WEST SUSSEX COUNTY COUNCIL CONSULTATION

TO:	Arun District Council FAO:Amber Willard
FROM:	WSCC - Highways Authority
DATE:	13 November 2020
LOCATION:	35 Kings Drive Bognor Regis PO21 4PZ
SUBJECT:	P/100/20/HH Single storey rear extension, first floor front extension and driveway with dropped kerb.
DATE OF SITE VISIT:	n/a
RECOMMENDATION:	Advice
S106 CONTRIBUTION TOTAL:	n/a

Proposed Site Plan

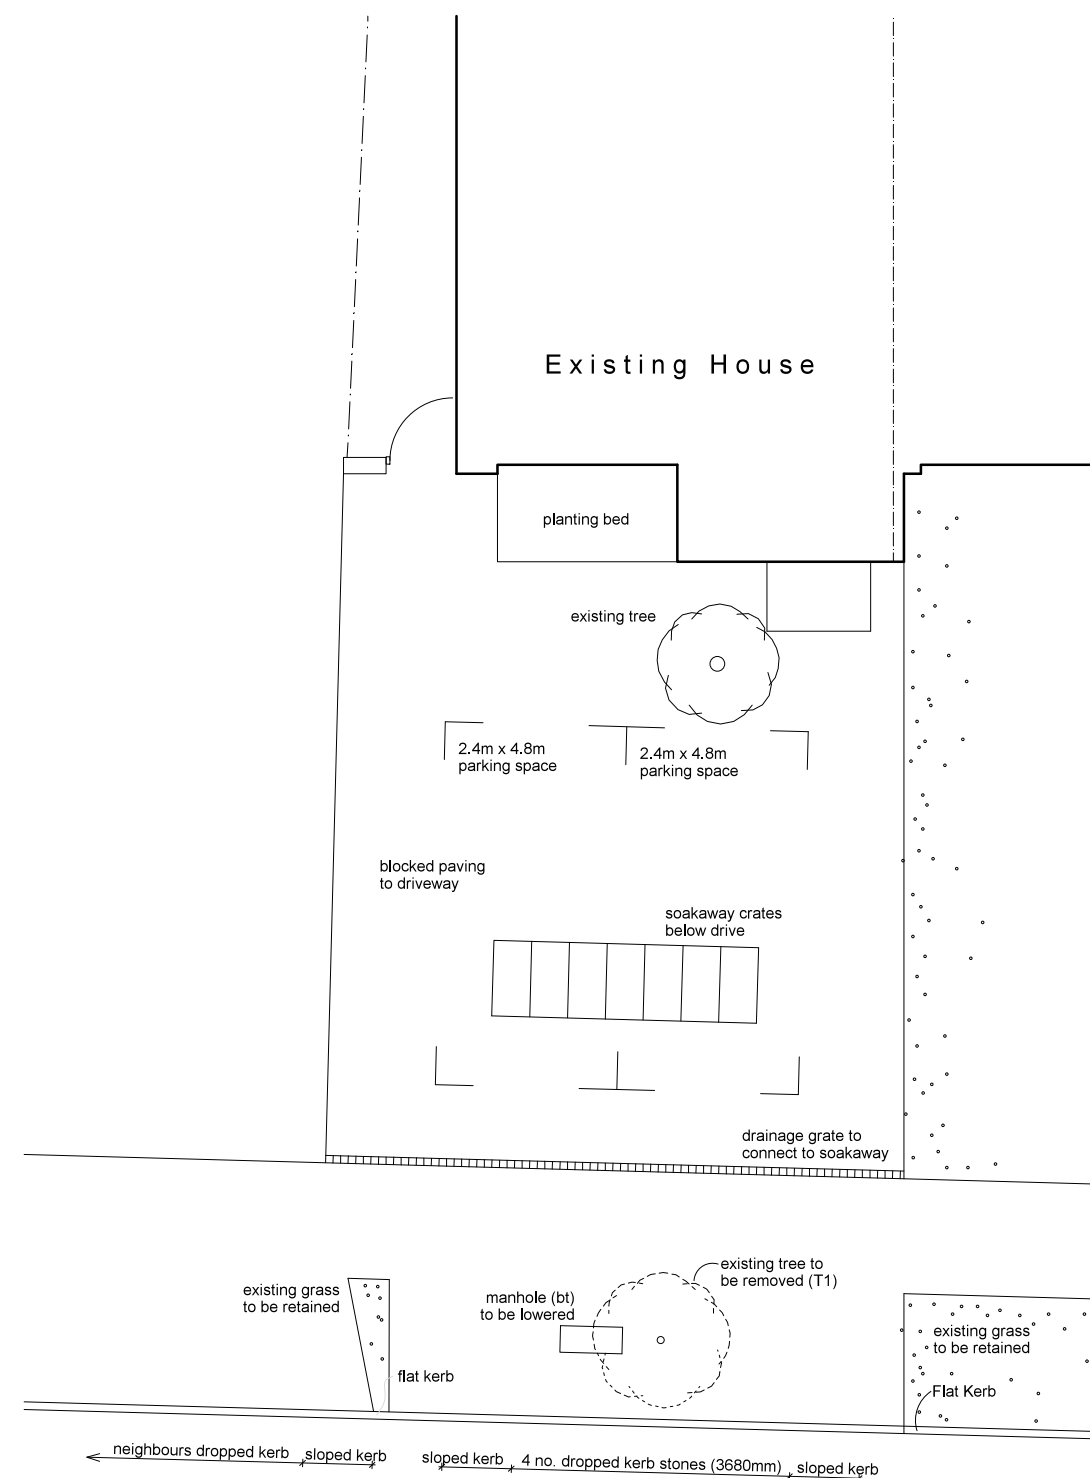
The application includes construction of vehicle crossover (VCO) onto Highland Road. The proposed access, as annotated on the site plan will be approximately 5.52m wide. Any access works onto the public highway must be constructed under a licence obtained from WSCC Highways, to a specification agreed with them. I note the presence of a highways tree fronting the property.

'The licence will most likely be refused as we don't take kindly to removal of trees. If the applicant agrees to fund a new tree elsewhere in the street (subject to consultation for a suitable location) then we might be agreeable but that will need someone to look into it in more detail than I can provide right now.'

From a highway safety perspective, the LHA cannot justify an objection as there are no overriding safety concerns, however the Area Office have confirmed that may not grant a licence due to their policy.

The use of the access shall not commence until such time as the vehicular access serving the development has been constructed in accordance with the details shown on the site plan.

The applicant is advised that in addition to obtaining planning permission that they must also obtain formal approval from the highway authority to carry out the site access works on the public highway. The granting of planning permission does not guarantee that a vehicle crossover licence shall be granted. Additional information about the licence application process can be found at the following web page:
